ENG-PUDSP21005-R2-GEC.pdf Markup Summary

Subject: Callout
Page Index: 1
Date: 11/1/2021 12:16:35 PM
Author: CDurham
Color:
Layer:
Space:
Page Label: [1] SHT 1 COVER

Subject: SW - Comment
Page Index: 1
Date: 11/15/2021 1:04:45 PM
Author: EPC Stormwater - Glenn Reese
Color:
Layer:
Space:
Page Label: [1] SHT 1 COVER

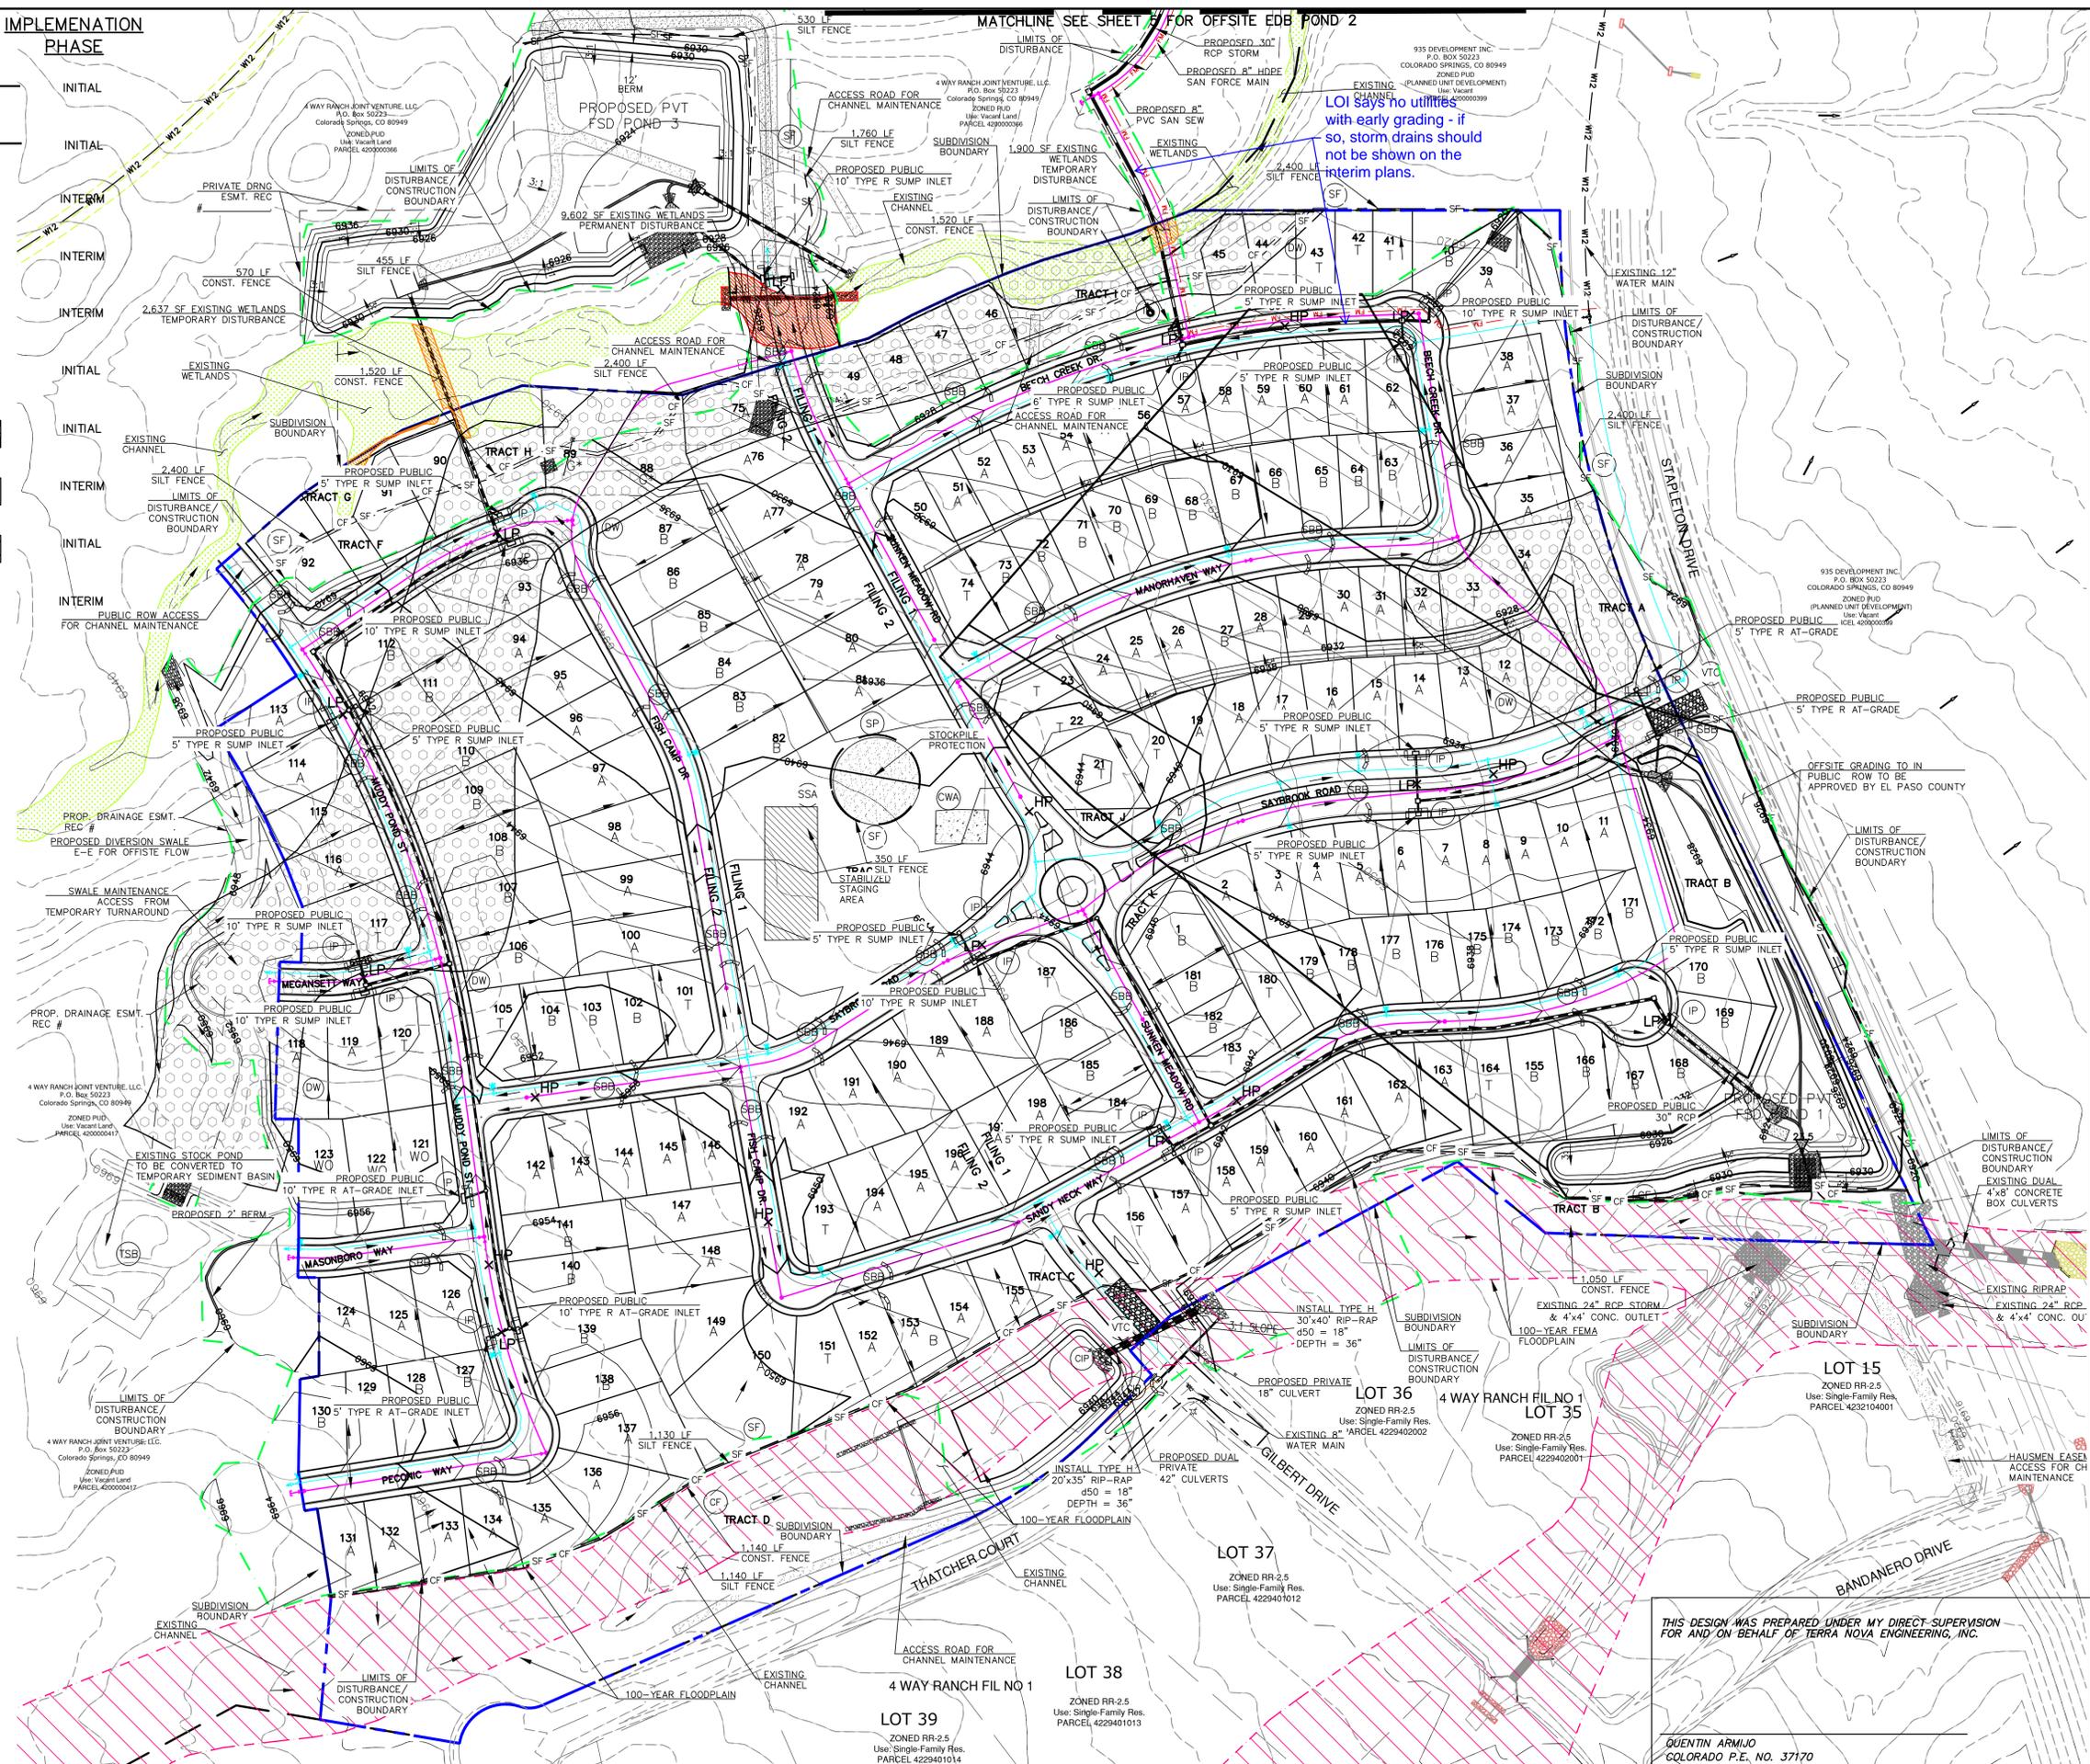
Subject: SW - Text Box
Page Index: 4
Date: 11/15/2021 12:44:41 PM
Author: EPC Stormwater - Glenn Reese
Color: ■
Layer:
Space:
Page Label: [1] SHT 4 EC INTERIM

Unresolved:
 Checklist Item "b" - label adjacent properties/subdivisions.

Unresolved:
 revise so linetype and color matches from plans to Legend.

Unresolved:
 Item H and M. If "limits of disturbance" and "construction boundary" are the same, change to "construction boundary/limits of disturbance" or otherwise show as separate linetypes for each on the legend and figure.

Unresolved:
 Label adjacent streets

Unresolved
 Checklist Item "f" and "g" - show existing structures and utilities.

Unresolved:
show linetype on Legend

Label existing road names

Complete the swale contours. Provide a cross-section.

Grading needs to be 50' from existing channel.

DONE

DONE

DONE

DONE

DONE

DONE

DONE

NO LONGER HAVE
SWALE IN THIS AREA

I NEED TO HAVE GRADING RIGHT UP TO CHANNEL
TO INSTALL BERM THAT KEEPS UNTREATED
RUNOFF FROM DIRECTLY ENTERING THE WETLAND

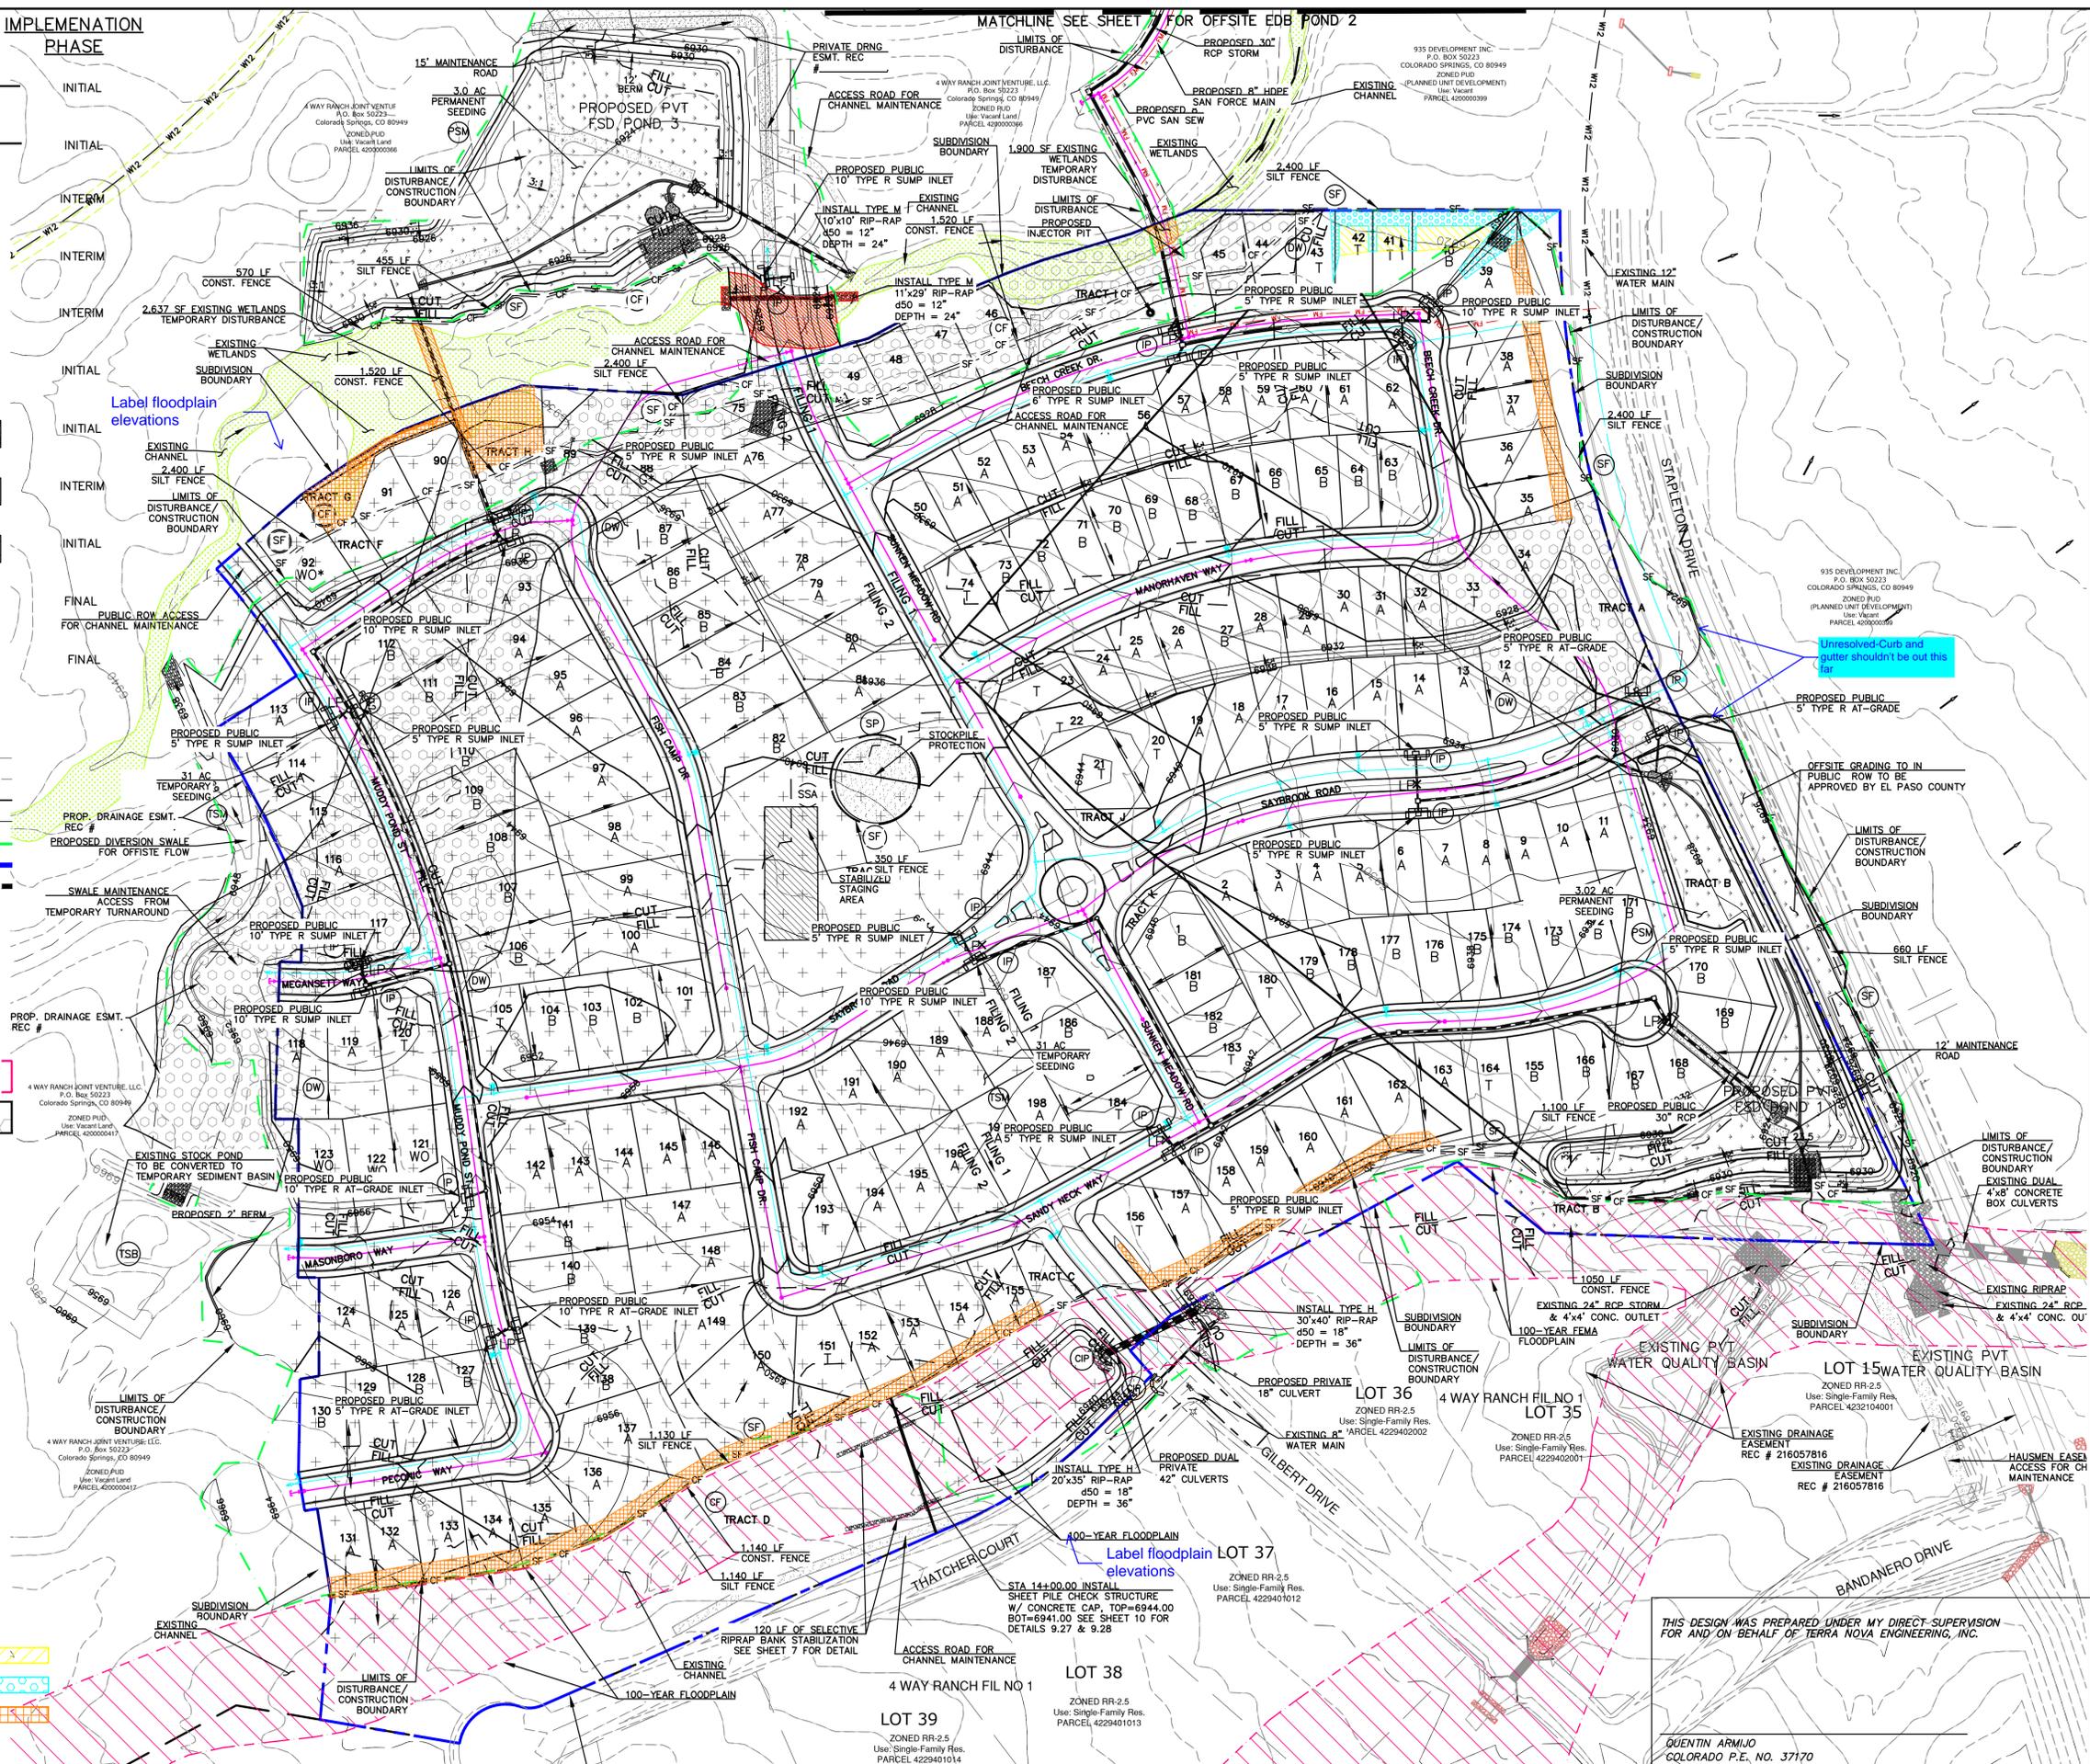
Missing proposed/final grading

Unresolved comment from Review #1:
Item H and M. If "limits of disturbance" and
"construction boundary" are the same, change to
"construction boundary/limits of disturbance" or
otherwise show as separate linetypes for each on
the legend and figure.

Unresolved: revise so linetype and color matches
from plans to Legend.

Unresolved:
Checklist Item "b" - label adjacent
properties/subdivisions.

Unresolved:
Label adjacent streets

Unresolved:
Checklist Item "f" and "g" - show existing structures
and utilities.

Unresolved:
show linetype on Legend

Curb and gutter shouldn't be out this far

show all contours

ditch?

DONE

DONE

DONE

DONE

DONE

DONE

DONE

NOT SURE
WHAT YOU
MEAN THIS C&G
IS TYING INTO
EXISTING

I DON'T HAVE CONTOURS FOR
EXISTING STAPELTON ROAD

NO DITCH
